Formal Planning Objection

Re: Planning Application 2026/62/90484/E – Change of Use from dwelling to C2 for 4 children, erection of first floor extension and front porch, internal and external alterations.

Property: 143 Church Lane, Gomersal, BD19 4QN

Proposed Front Elevation 1:100

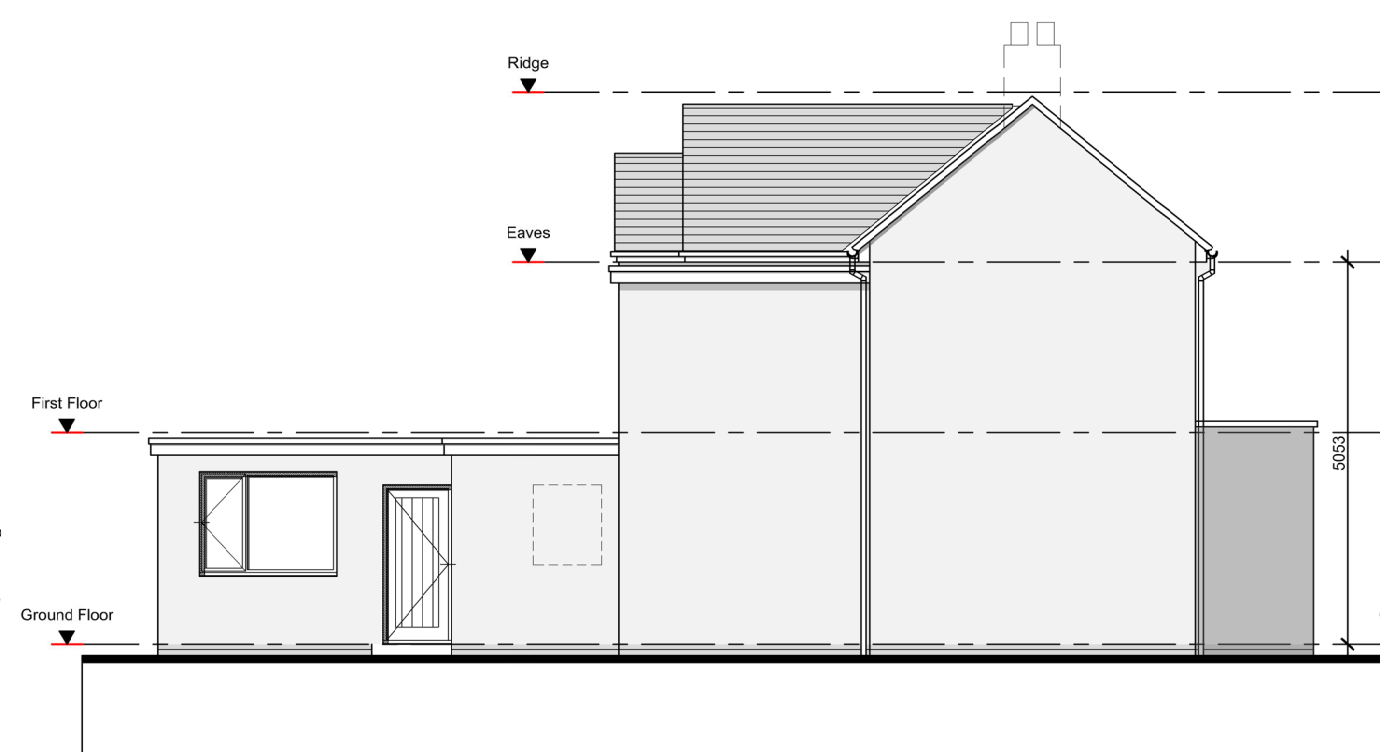
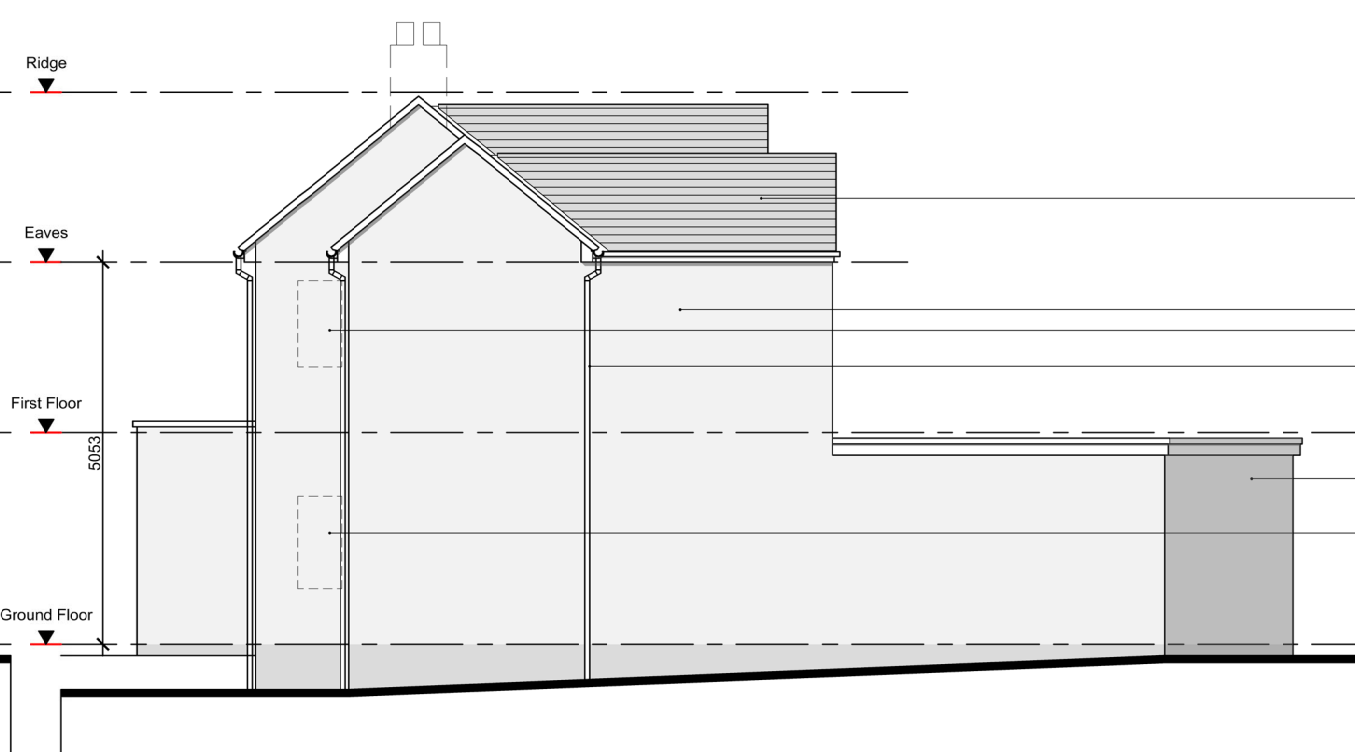
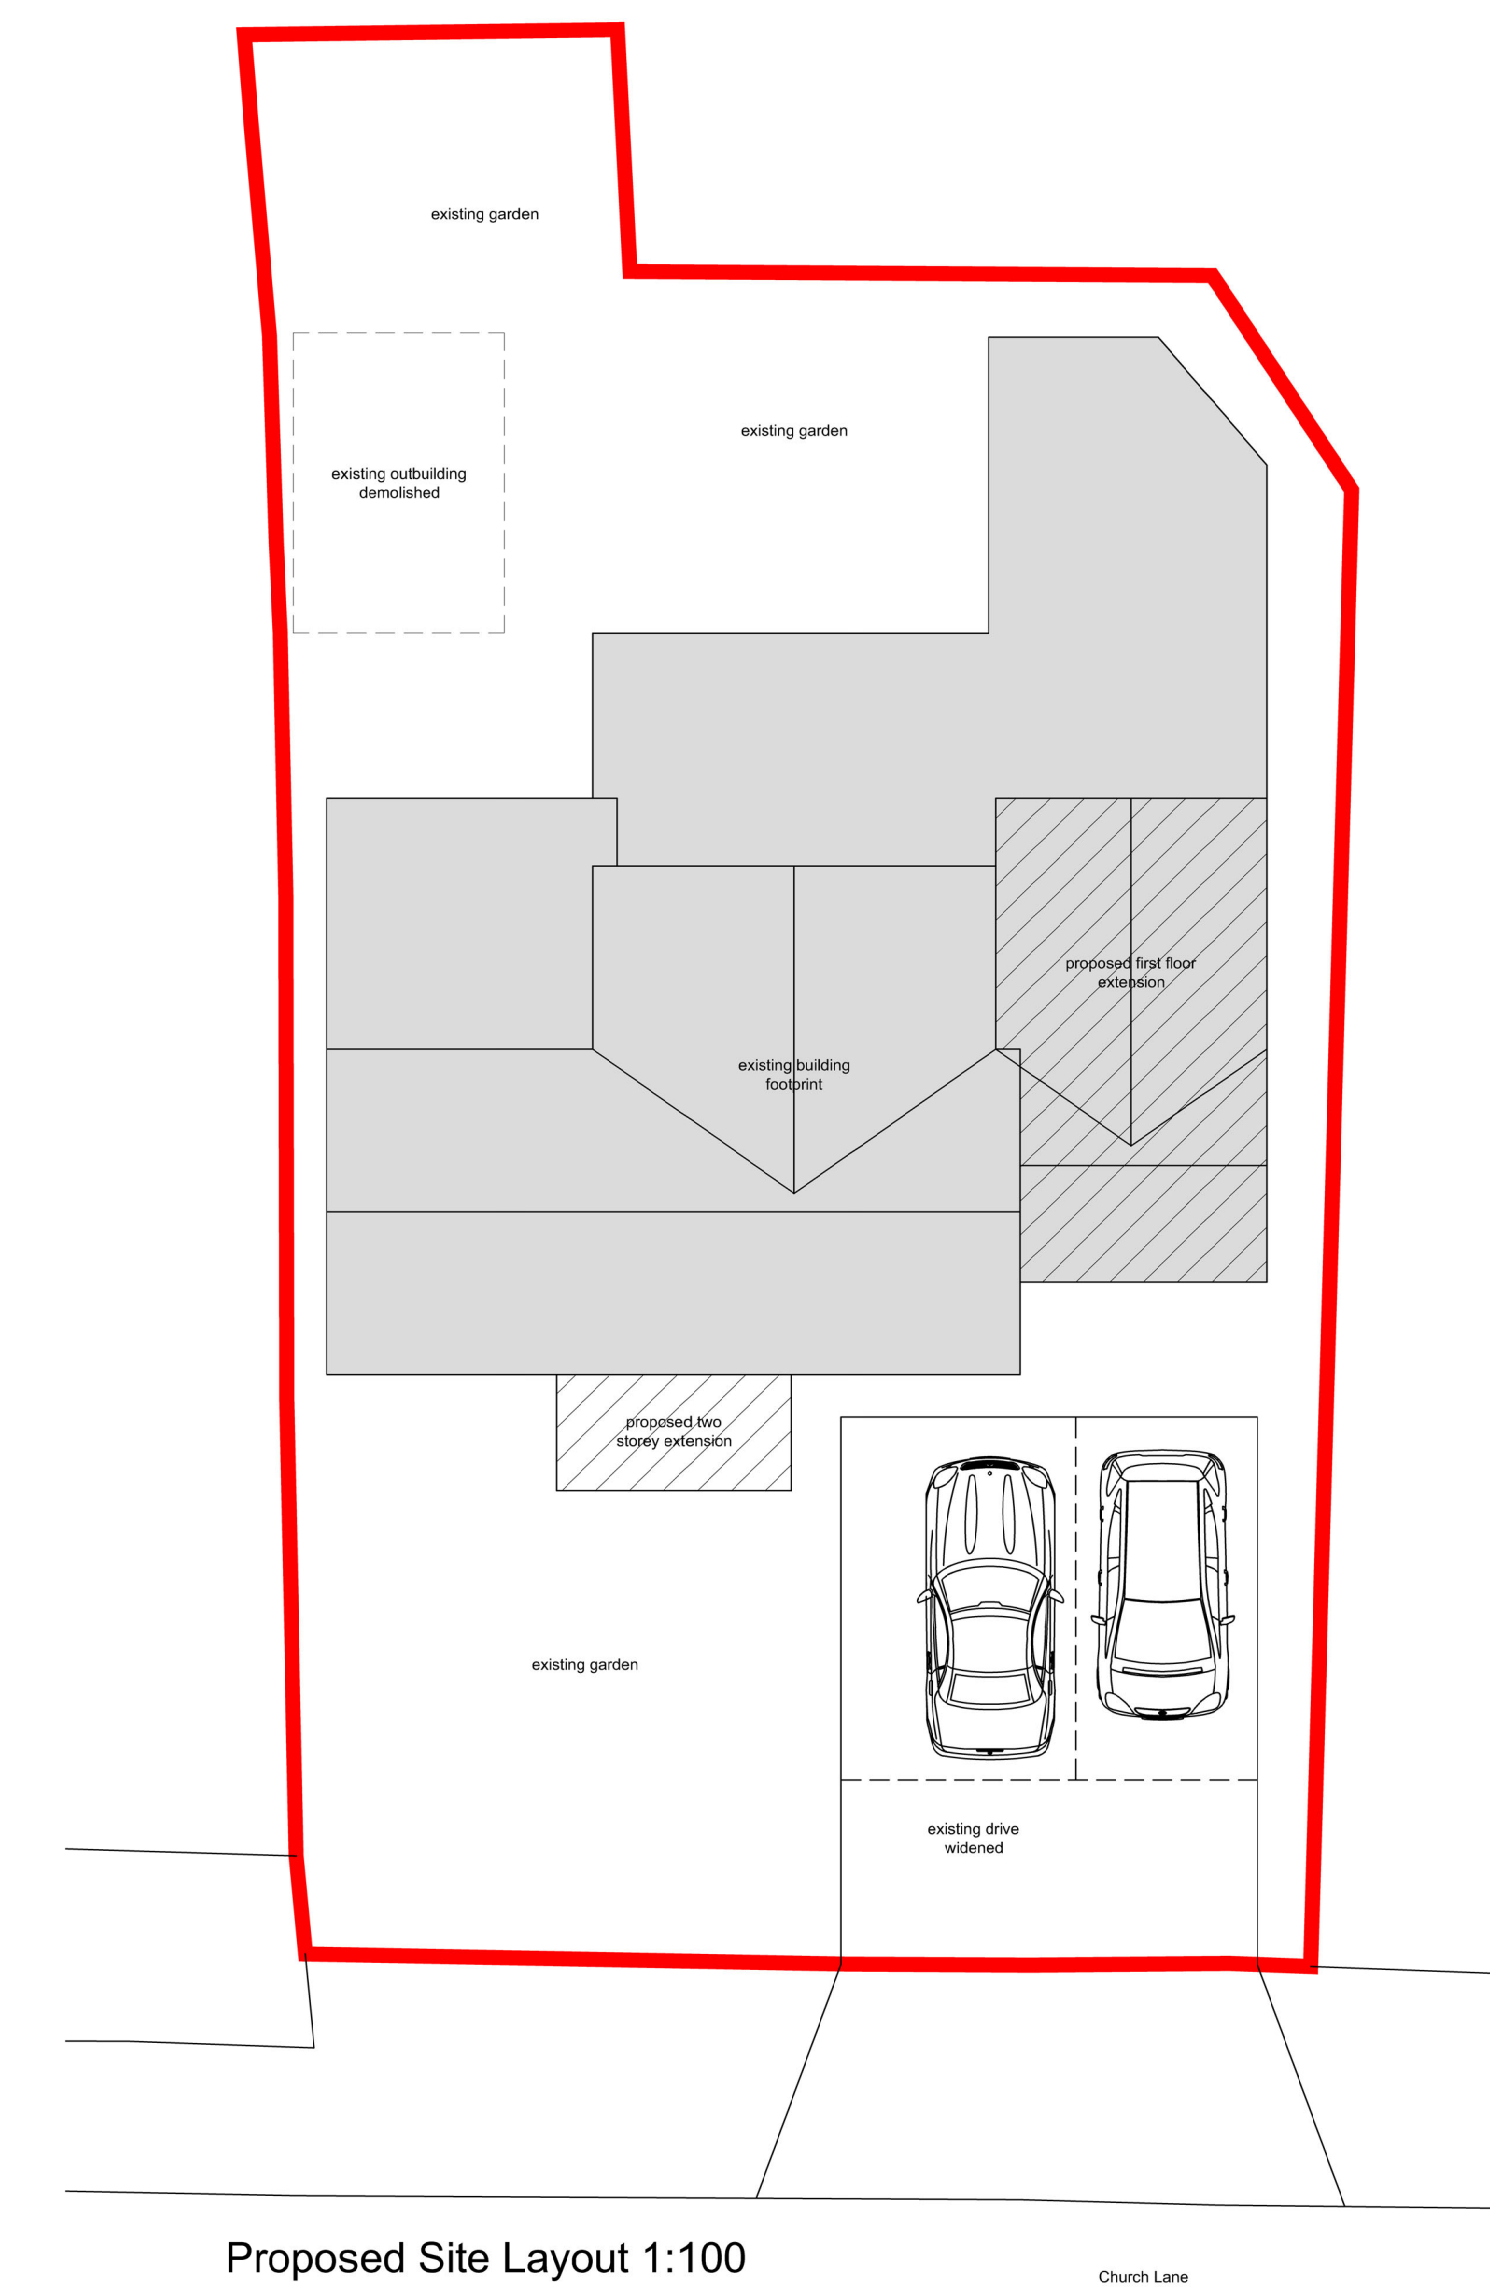
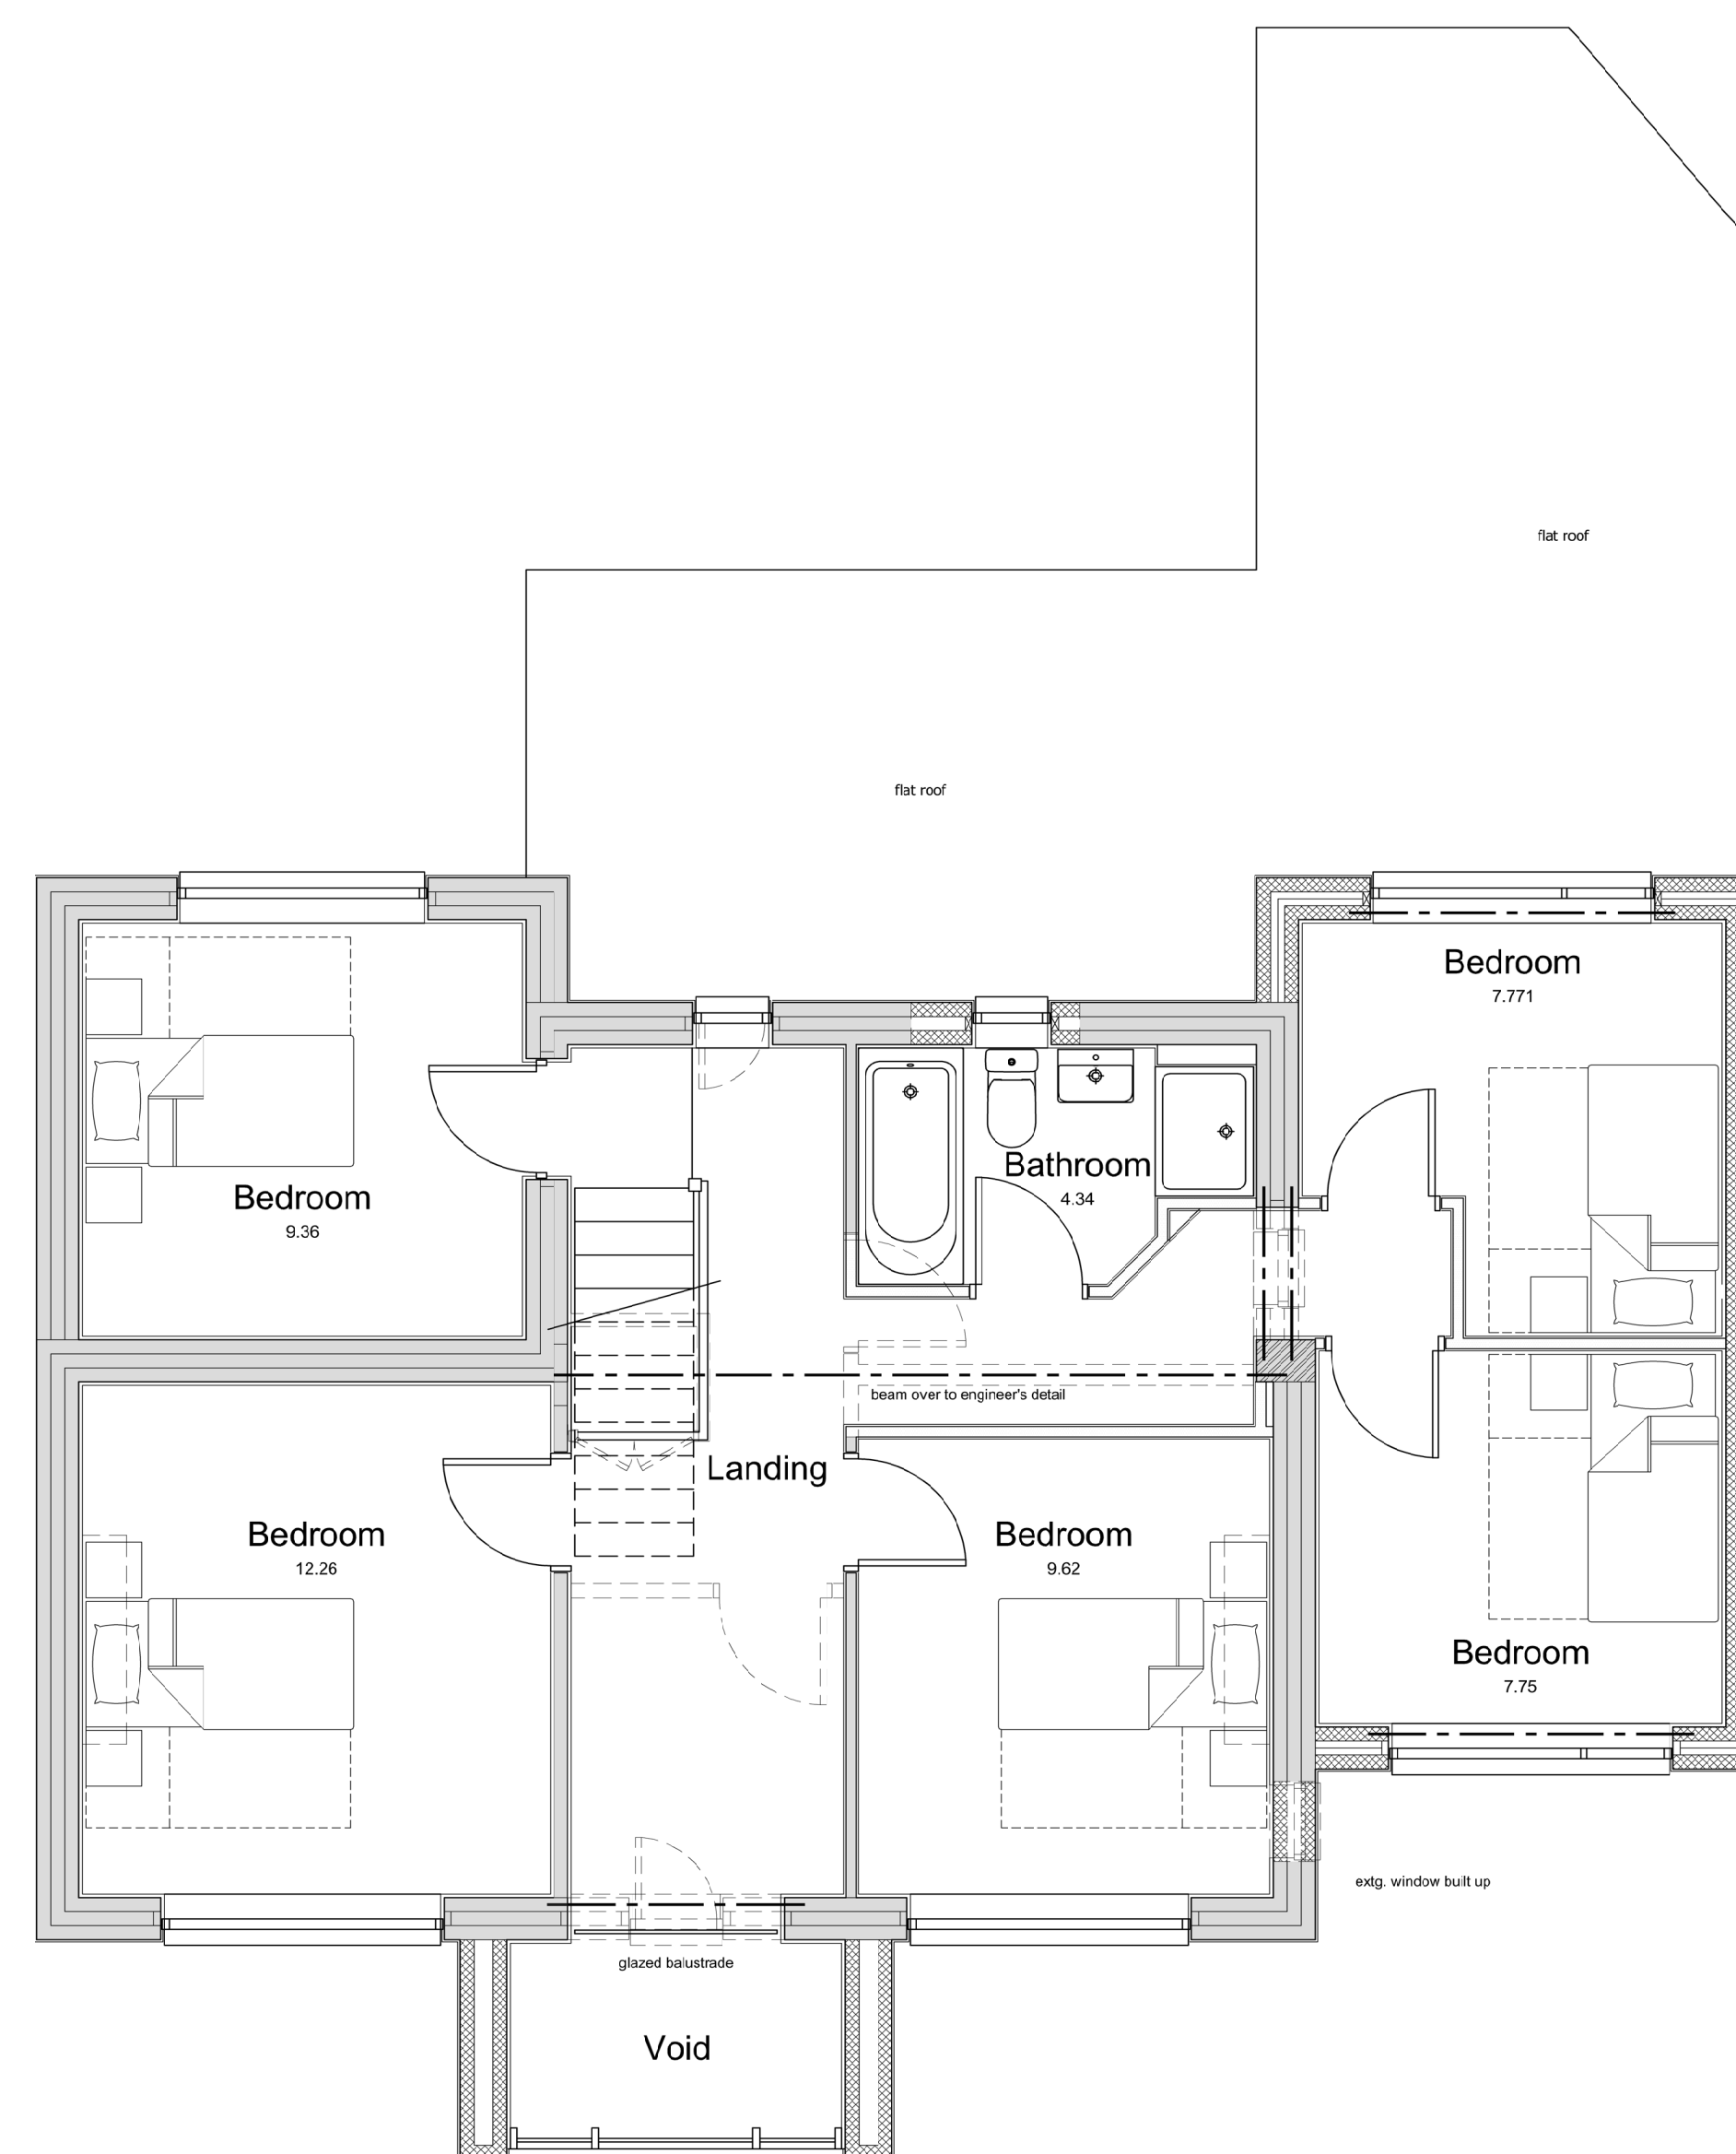
we have significant concerns regarding privacy and overlooking. The layout of the property, combined with its large floor-to-ceiling windows on the front elevation and the positioning of upper-floor circulation spaces such as the landing, would result in clear and direct sightlines towards neighbouring homes and gardens. The proposed use would involve multiple residents and staff regularly occupying these areas throughout the day and night, which would substantially increase the potential for overlooking compared to the existing use as a single private dwelling. This would materially reduce the level of privacy currently enjoyed by neighbouring properties, particularly given the close proximity between the two houses. Policies within the Kirklees Local Plan and national guidance within the National Planning Policy Framework require development proposals to safeguard the residential amenity of neighbouring occupiers and prevent unacceptable levels of overlooking or loss of privacy. In our view, the proposed change of use would significantly intensify activity within the property and create a harmful level of overlooking and loss of residential privacy for adjoining residents.

The property plans propose a very large floor-to-ceiling window on the front elevation which directly faces the public highway.

This design would leave residents, including potentially vulnerable children, highly visible to the public when occupying the entrance hall or upper landing areas. Such a lack of privacy may be detrimental to the emotional wellbeing and safeguarding of the residents themselves.
